Your ref: 3/2023/0695
Our ref: DC/23/3123
Date: 18-SEP-23

Location: Stanley House Preston New Road Mellor BB2 7NP

Proposal: Approval of details reserved by condition 4 (drainage) of planning permission 3/2020/1059.

Status:	PRELIMINARY	Drawn By:	RCTS	Date:	31.07.2023	Scale:	1:200
Drawing No.:	LM_23004-102	Rev:	P2

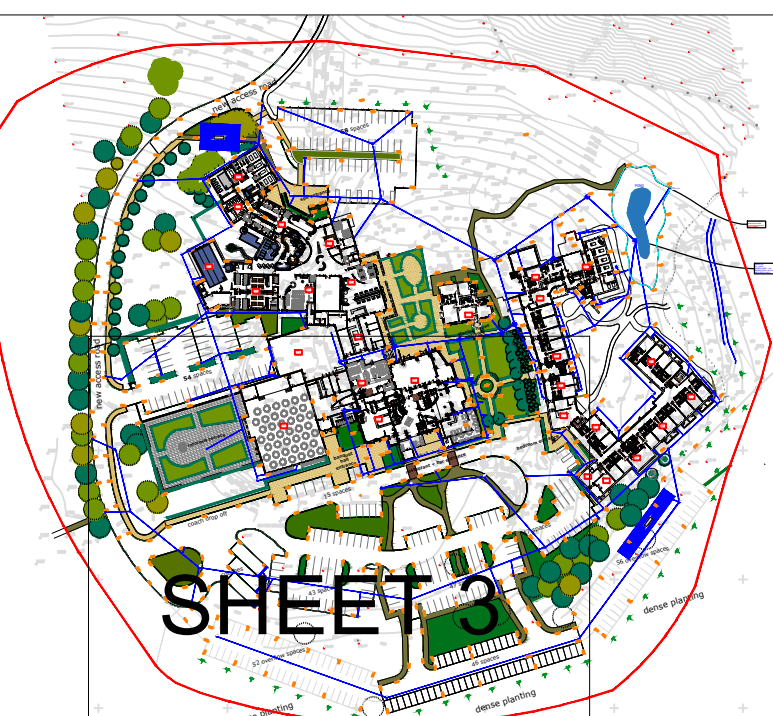
Further to our review of the submitted documents, Drawing LM_23004-101, Rev P1 - Dated 31.07.2023, United Utilities recommends that condition 4 is not discharged. Please can the applicant submit a plan showing the foul connection from the private network into the public sewer as well as in Finished Floor Levels (FFL) in AOD.
